**Pitt Street South Over Station Development Stage 2 (SSD-10376)  
Response to Submissions**

Thank you for your correspondence via the Major Projects Portal on 28 September 2020, requesting Transport for NSW (TfNSW) to review and comment on the above.

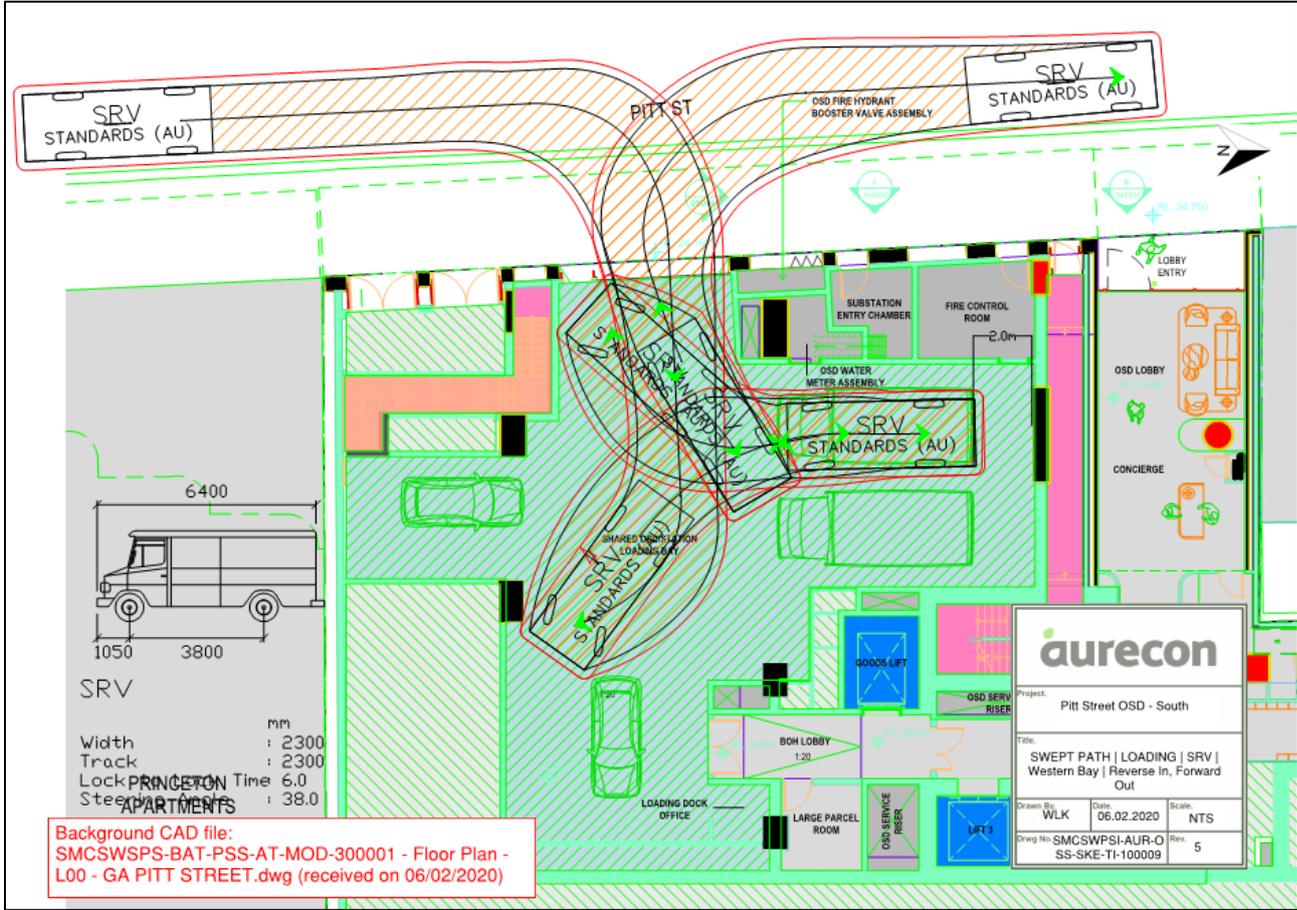
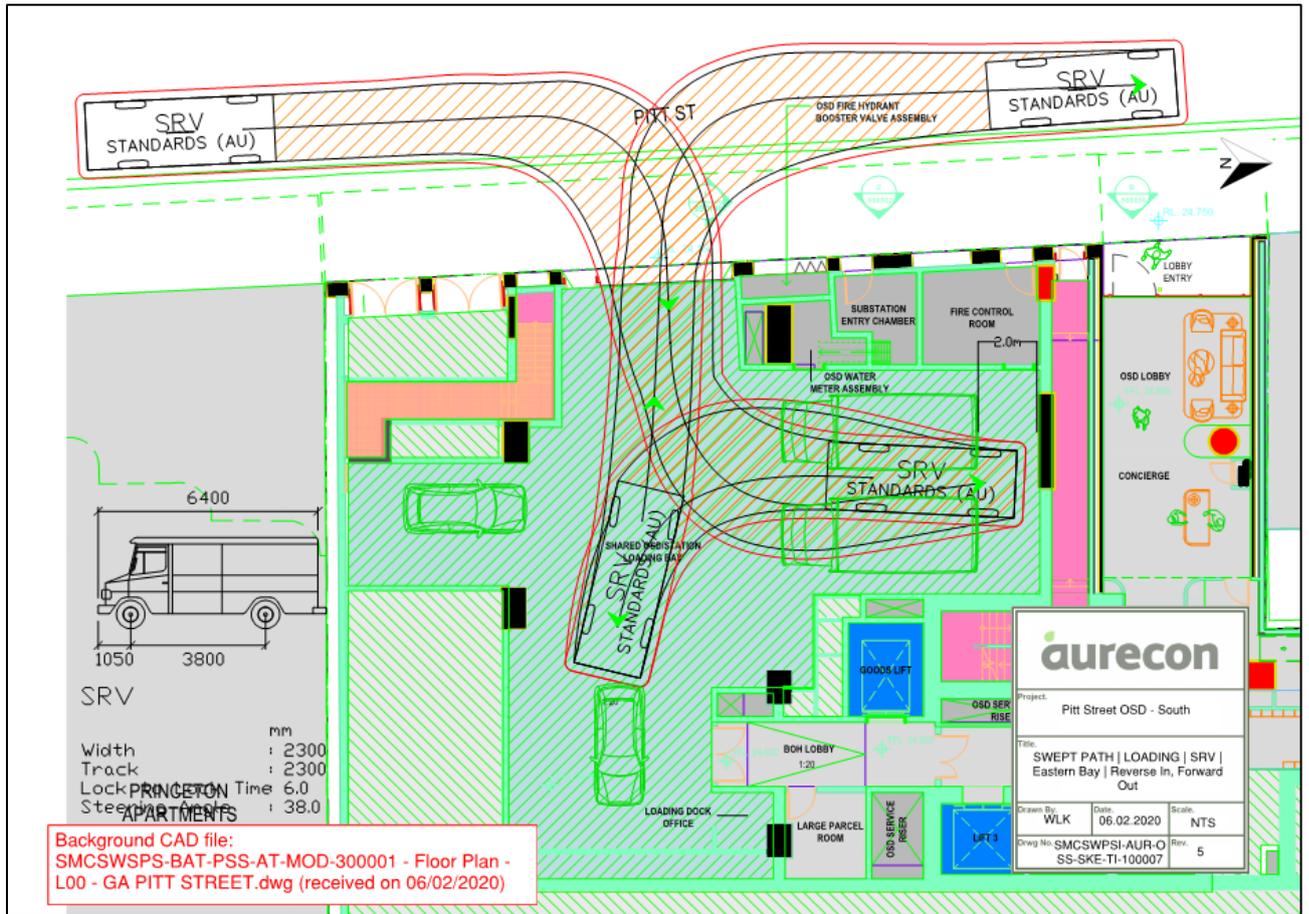
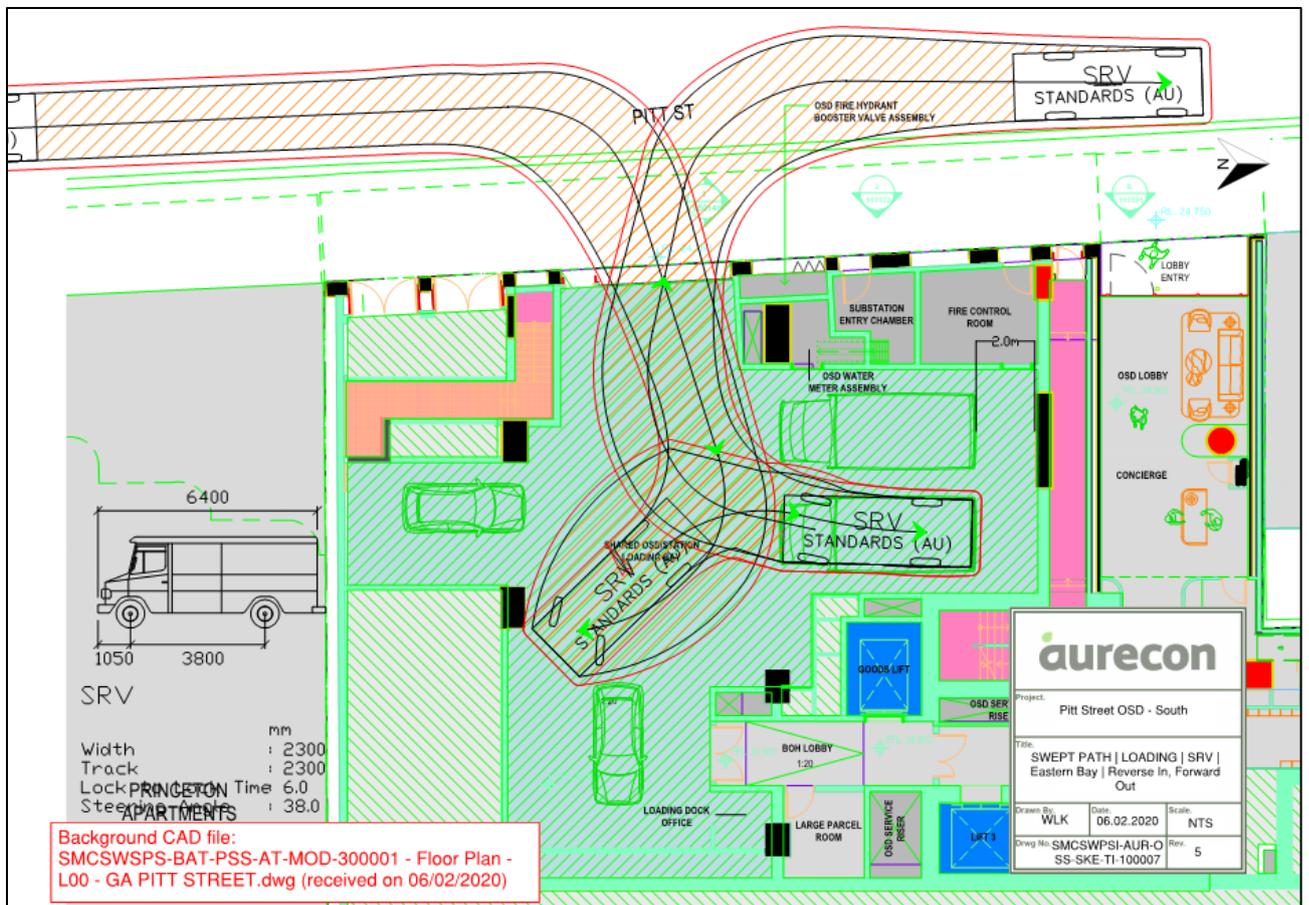
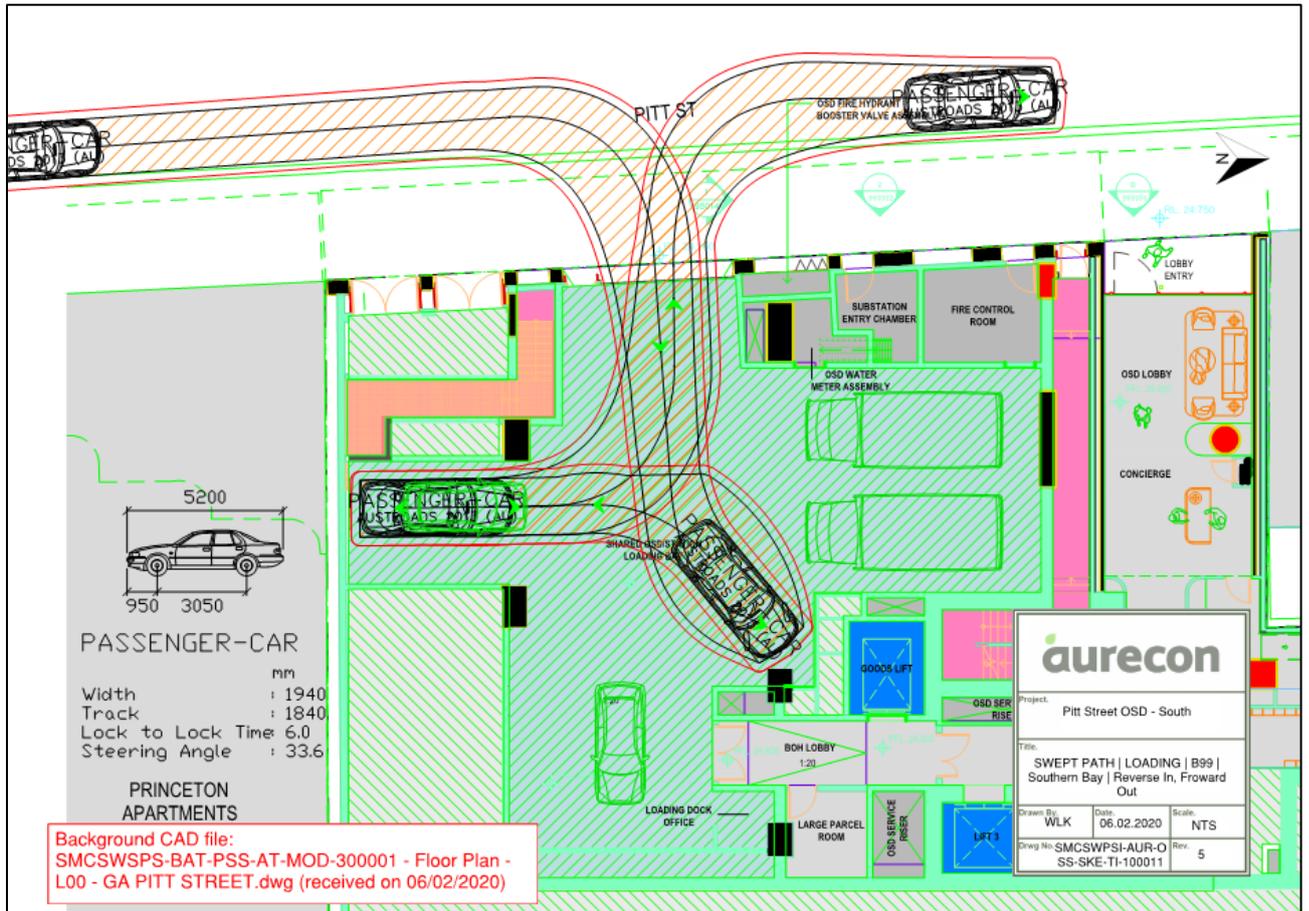
*Due to the spatial constraints of the loading dock service vehicles will need to reverse into/out of loading bays. The swept paths in the Transport and Accessibility Impact Assessment (Appendix D) shows that the vehicles will not require more than three points turn to manoeuvre in and out from service bays. This does incur the risk of pedestrian vehicle interaction. To mitigate potential risks to cyclists and pedestrians an audible and flashing light warning system is proposed to be installed to alert the surrounding pedestrians and cyclists of incoming and outgoing commercial vehicles from the loading dock.*

- The above response does not address the concern within the loading dock where there will be reversing manoeuvres of SRV's and B99's occurring on a regular basis with cyclists moving within this loading dock space to get to and from the dedicated bicycle parking;
- The proposed development includes build-to-rent residential accommodation. Some of the cyclists are expected to be children. Therefore, safety of all type of cyclists needs to be managed within the loading dock by proper pedestrian/traffic control measures rather than audible and flashing light warning system; and
- Any errant vehicle would have the potential to cause cyclists related safety incident during the reversing manoeuvres within and access to the loading dock.

- Undertake a Stage 3 (Detailed Design) Road Safety Audit for the Loading Dock arrangement including cyclist movements within the loading dock in accordance with the relevant Austroads Guidelines by an independent TfNSW accredited road safety auditor, prior to the issue of any Construction Certificate; and
- Prepare a Pedestrian and Cyclists Safety Plan for the loading dock in consultation with the Customer Journey Planning within TfNSW, prior to the issue of the Occupation Certificate.
